From: Colin Giddings
Sent: 04 January 2018 10:36
To: Planning.Responses
Subject: FW: Planning Consultation on: LU/375/17/PL and LU/376/17/OUT

In respect of the proposal for a residential mobile home development and the proposed residential development I would comment as follows:

Site Address: The Bungalow Southdown Nursery Old Mead Road
Littlehampton BN17 7PU

Change of use of land for the stationing of 25No. mobile homes for permanent residential occupation

TITLE
Thornlea Park, Littlehampton
Proposed Site Layout
Mobile Homes

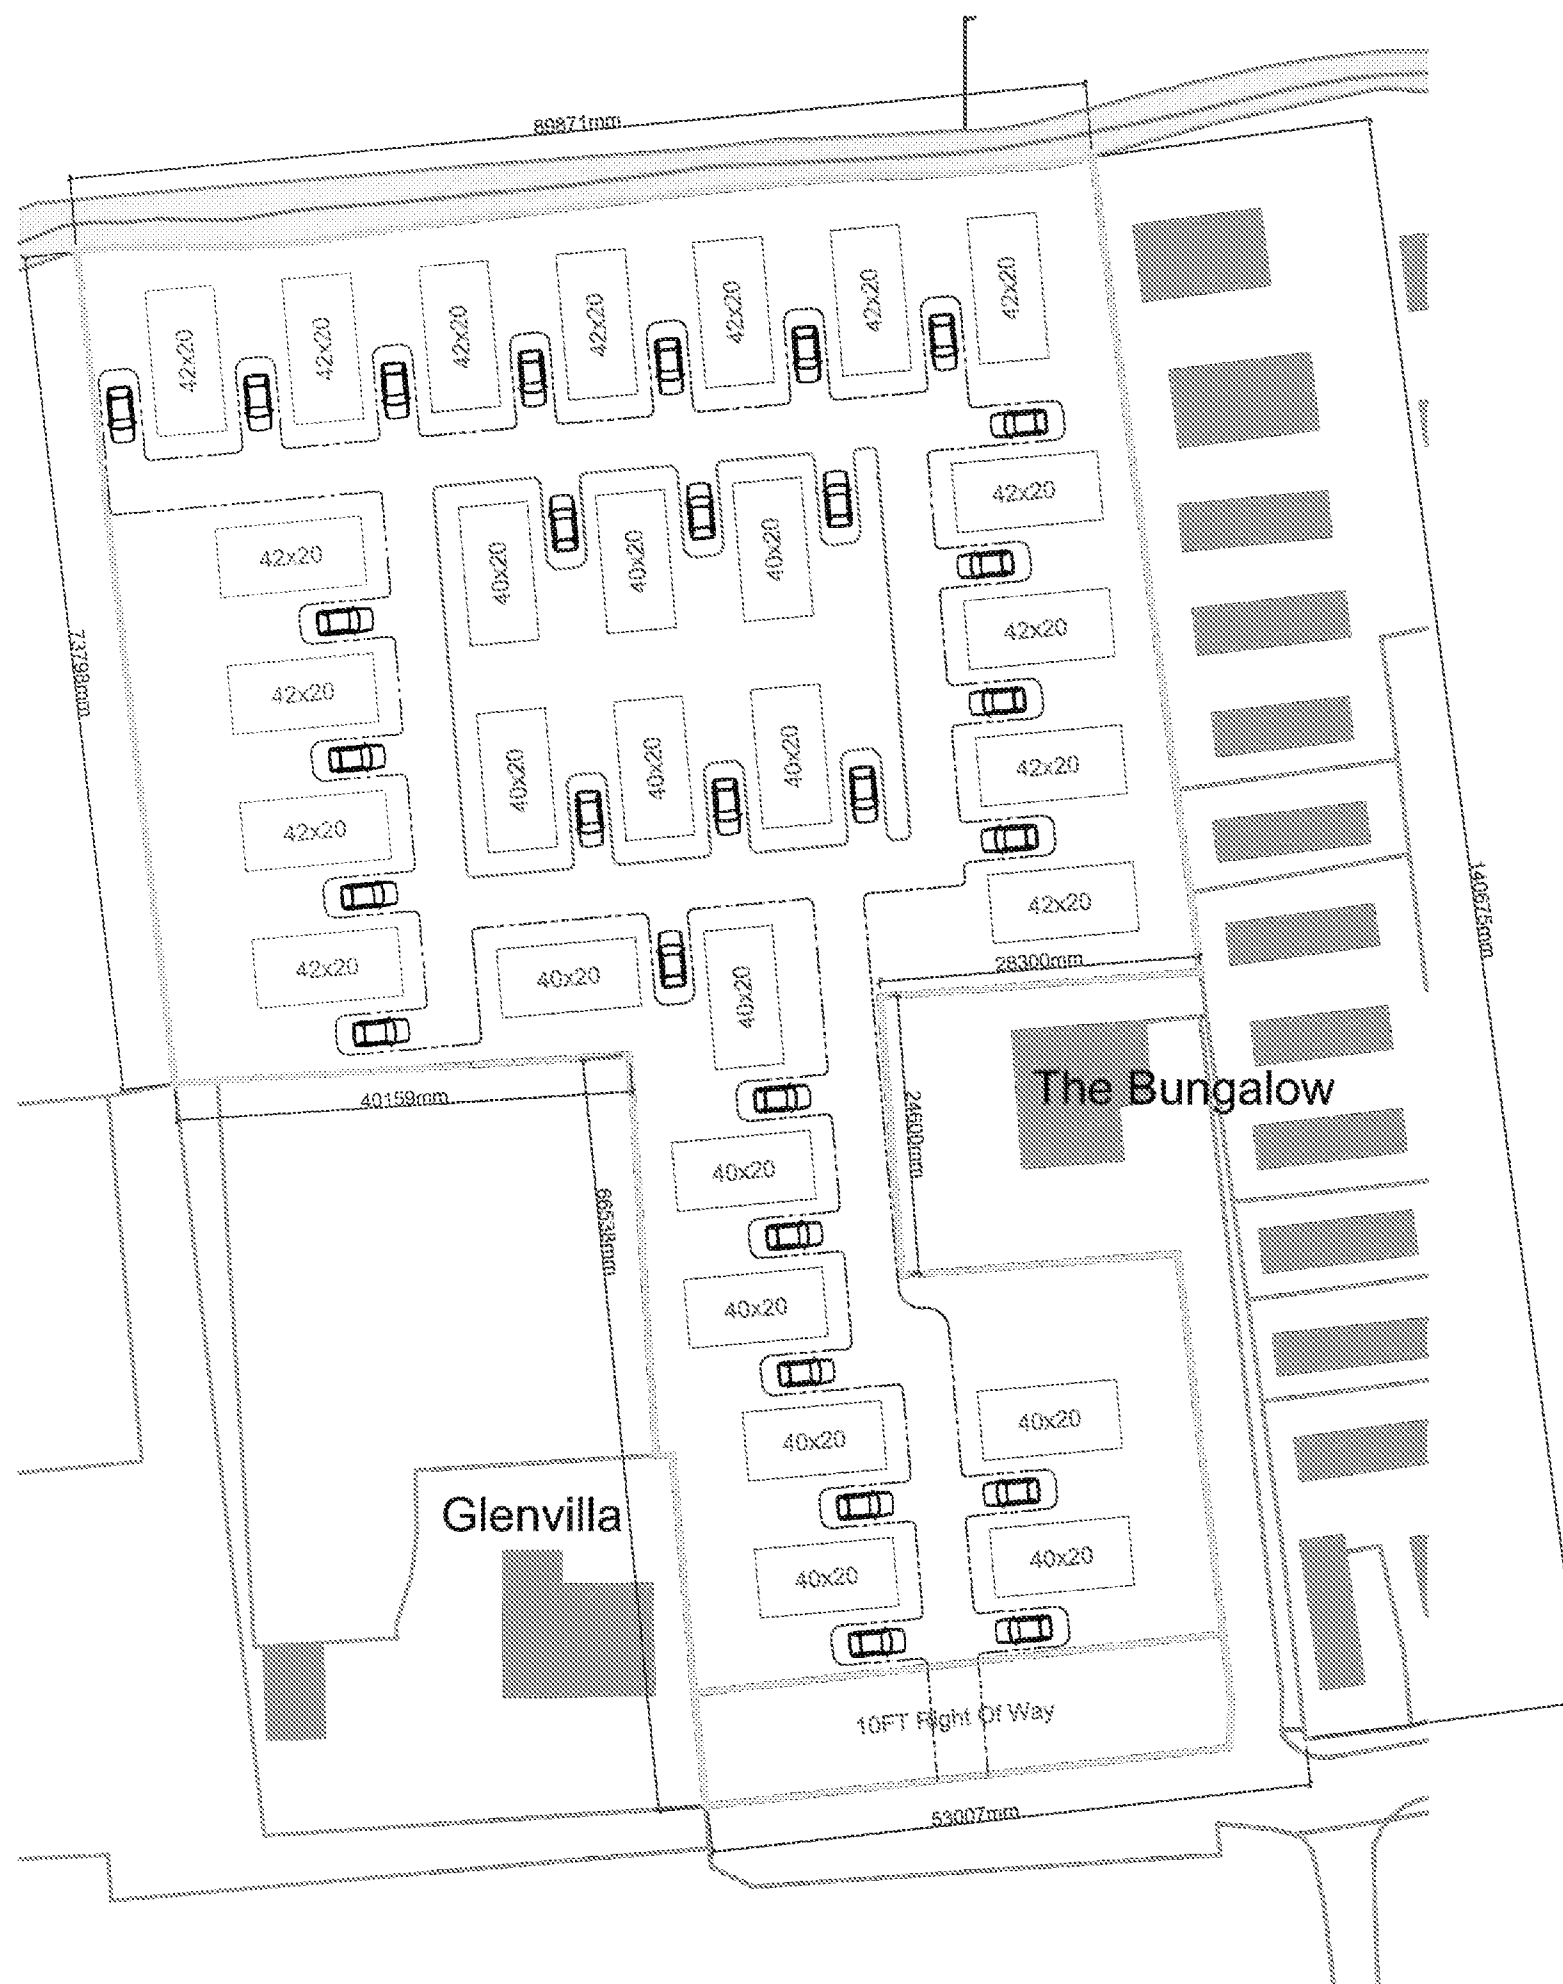
There is insufficient detail provided for the assessment of mobile home provision. Without a detailed and approved scheme, including a site plan, specifications for pitch construction and size, details of drainage, electricity supply, gas supply, water supply and other services, road construction and the provision of recreation space, I recommend refusal of the mobile homes option.
